1 April 2026

**This is a formal Objection to State Significant Development SSD-96505456 –
Cammeray Seniors Living, 19–23 Rosalind Street, Cammeray NSW 2062**

DRAWING TITLE
LOWER GROUND - PROPOSED PLAN
 DRAWING NUMBER
 DA-101
 REVISION
 A

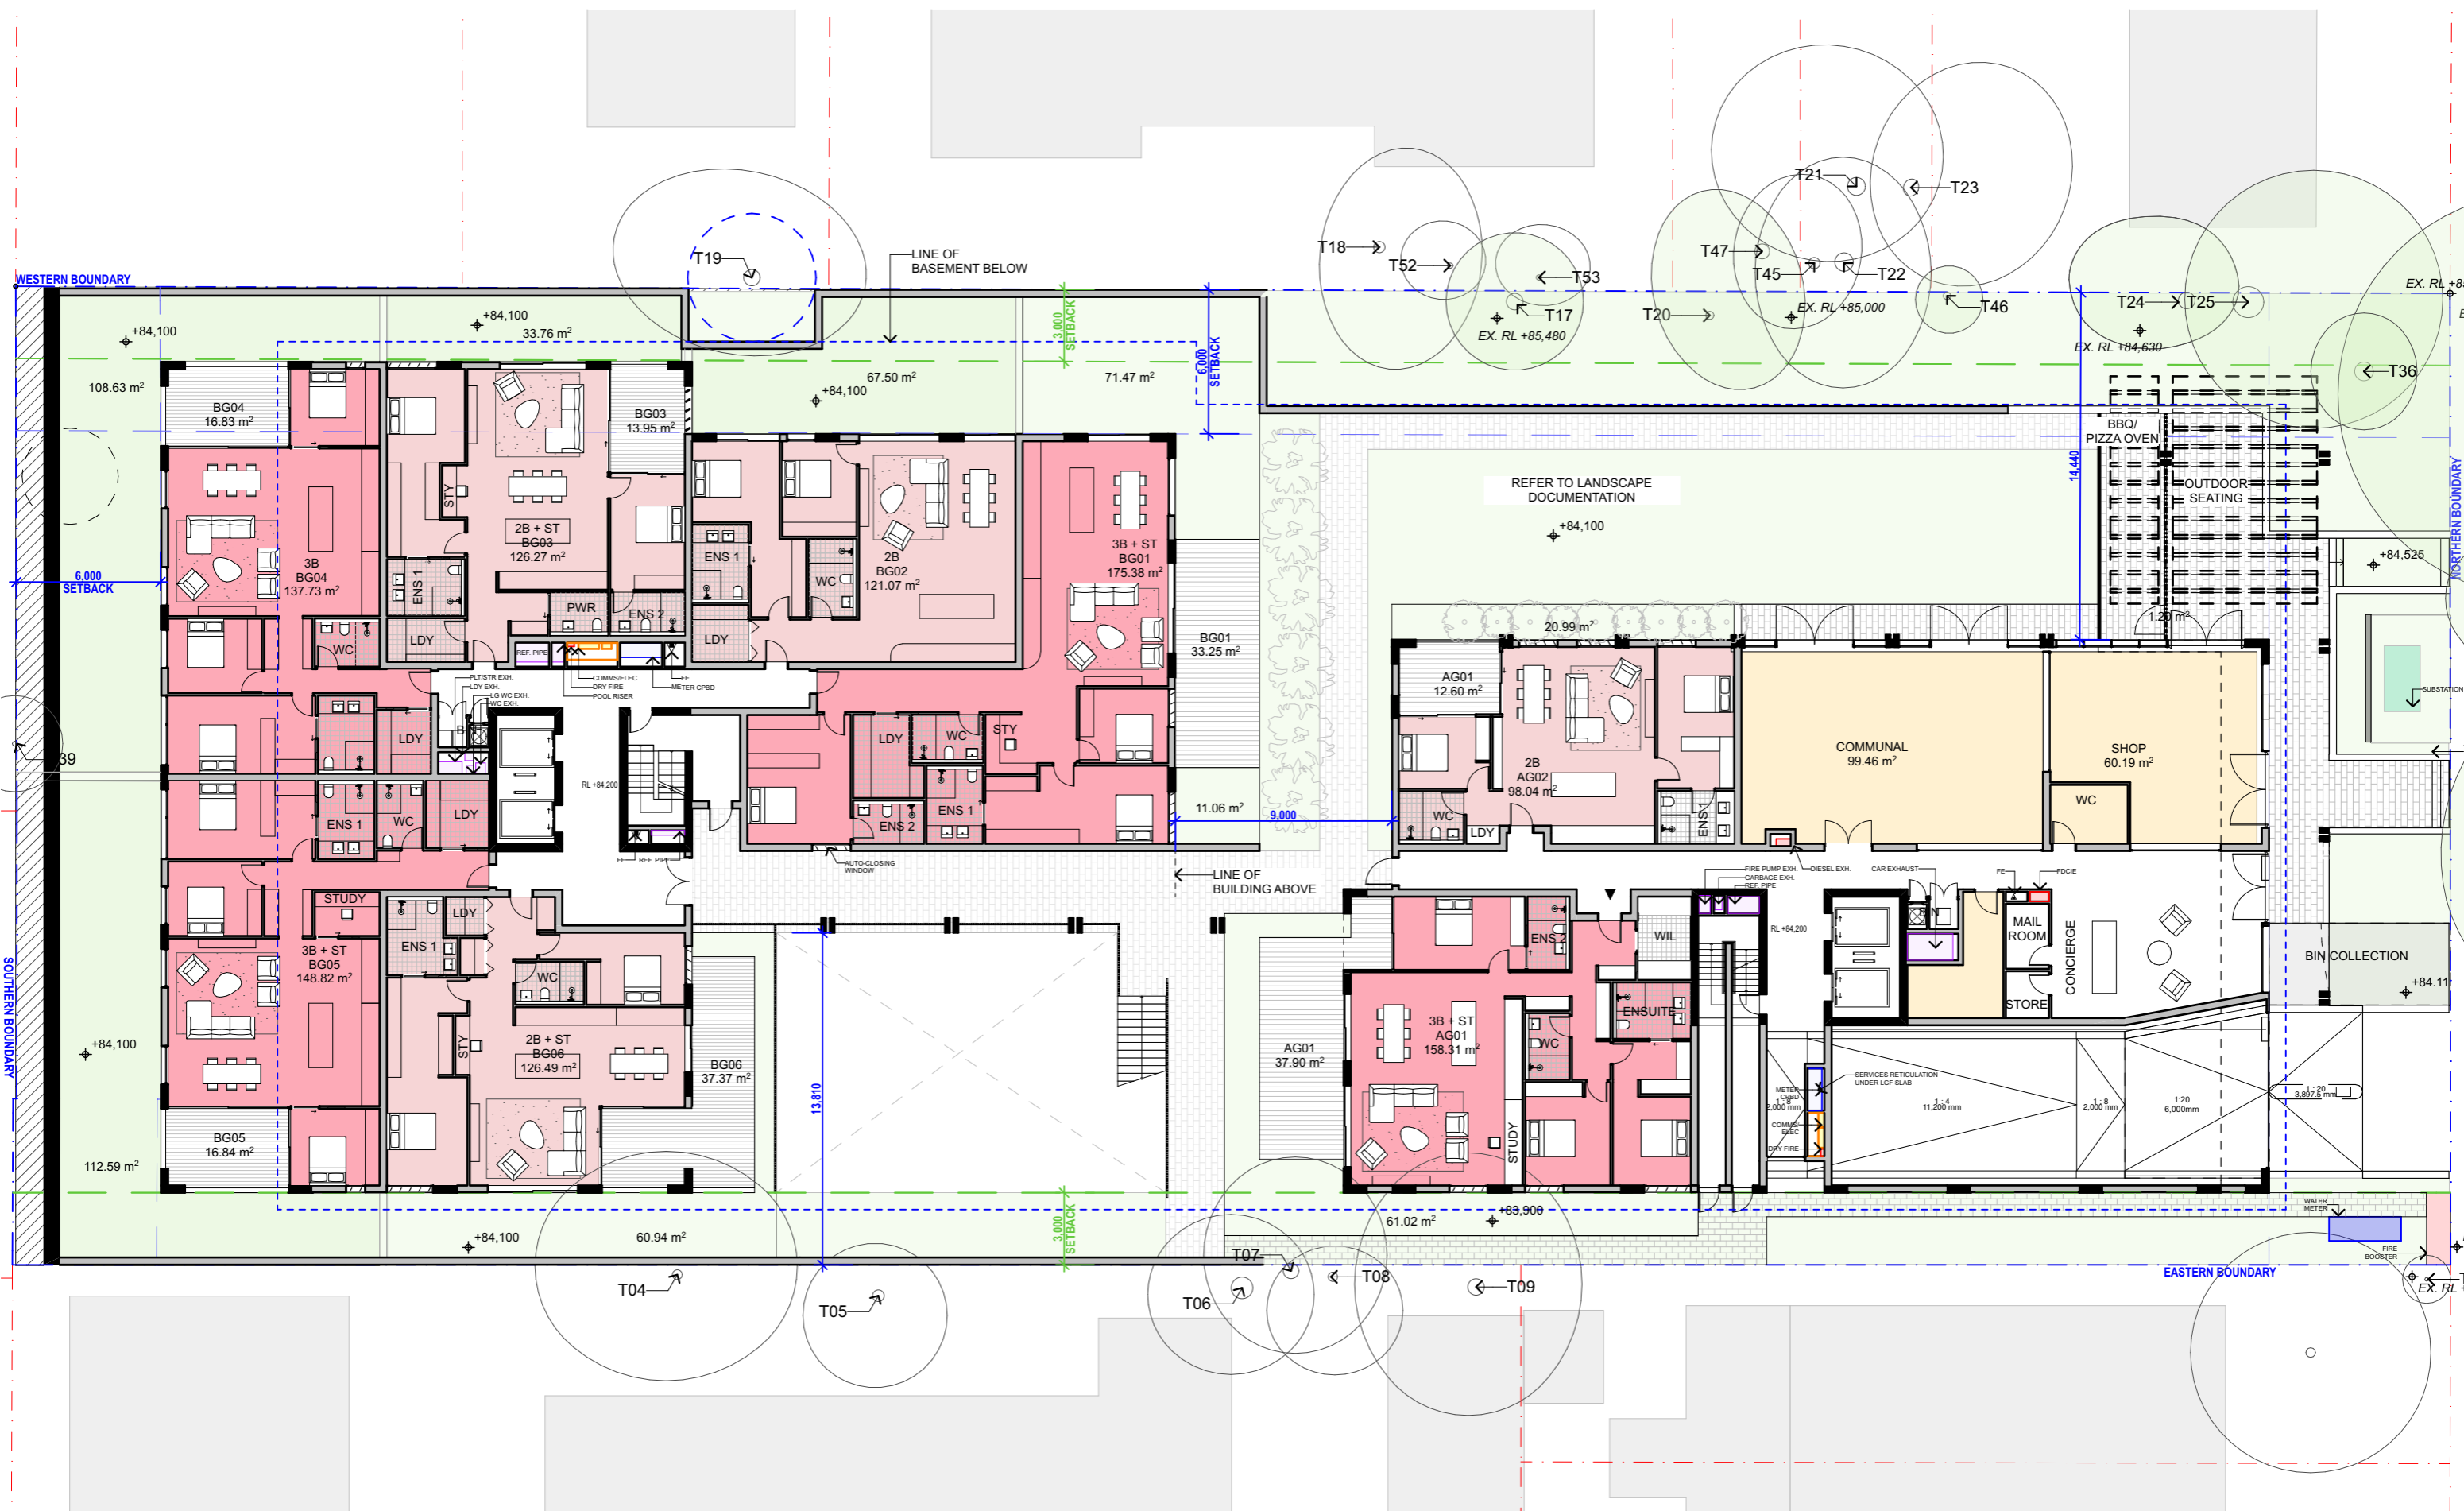
The pool plant room and building plant room in the lower ground floor on the western boundary, adjacent to my home raise noise and vibration concerns as bedrooms in my home face this boundary. The location of the waste service pipe for Building B is unclear in the EIS documentation.

In response, to protect my amenity, acoustic barriers and roof-level venting must be implemented to ensure no noise, vibration, or fumes are emitted toward my home. Waste infrastructure must not be located along the Western boundary adjacent to my home.

As the proposal is meant to provide housing options for Seniors, which are a more vulnerable group of people in our community, the inclusion of 2 care beds underground in the lower ground floor appears tokenistic, especially as the solar diagrams show they will receive no direct sunlight in mid-winter and they will only be run on an 'as needs' basis. These beds will also look out to a shared courtyard which means that if a resident was using these rooms, they would not be able to open the blinds if they wished to maintain privacy but have an outside outlook.

Figure 14 Location of upper level massing

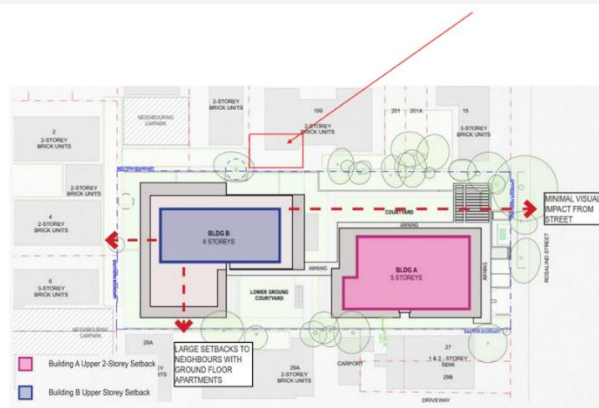
I have also noted that Level 4 is the 5th storey of Building B. As such, this level must have an additional 3m setback from the boundary, as per Apartment Design Guidelines (ADG) for buildings of 5-8 storeys. This additional setback has been provided to all other neighbouring properties which face Building B but has not been provided to my home to help mitigate privacy and overlooking impacts.

- A minimum separation of 15 metres (12m + 3m) should be provided in accordance with the ADG from the ground floor level of Building B on the Western Boundary to ensure an appropriate transition between zones, given my home is within a lower-density R3 zone.
- Additional 3m setback applied to Level 4, as per ADG for Building 5-8th storeys high.
- I also wish to ensure that the setback of Level 4 Building B which faces Rosalind Street is not decreased as I note that this assists with ensuring solar access is maintained to my home, as well as providing this ILU with a northerly aspect.
- I also wish to ensure that permanent privacy screens are installed on all western and northern-facing windows and balconies to: BG01, BG02, BG03, B01, B102, B103 (north), B202, B203 (north), B302, B303 (north), B402, and B501.

Location of Lily Pilly trees on Western boundary highlighted in yellow.

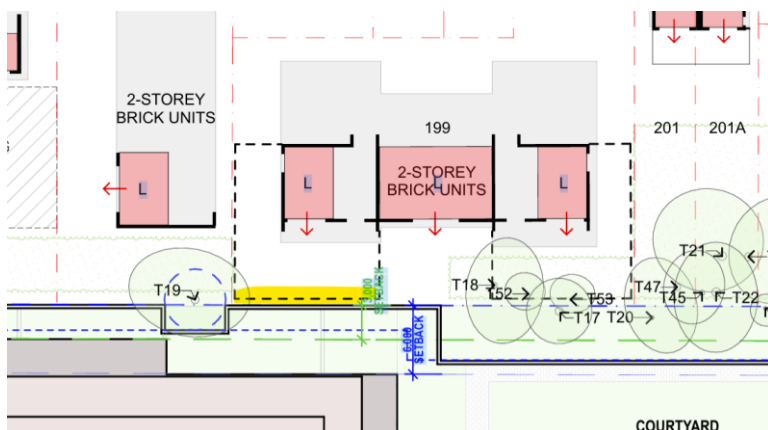
I am also concerned about the Lilly Pilly trees on our property boundary which provide vital green canopy and a visual screen to the low rise building currently on the site. Despite the Arboricultural Report assessing trees on neighbouring properties, these trees along our Western Boundary were ignored. These are in a vulnerable position, given the proposed deep excavation immediately over the boundary.

To mitigate further environmental impacts and protect neighbour assets I request that the Department requested that our Lilly Pilly trees are assessed by the Arborist and that a tree protection zone is applied around these trees, to ensure they are not damaged during the deep excavation.
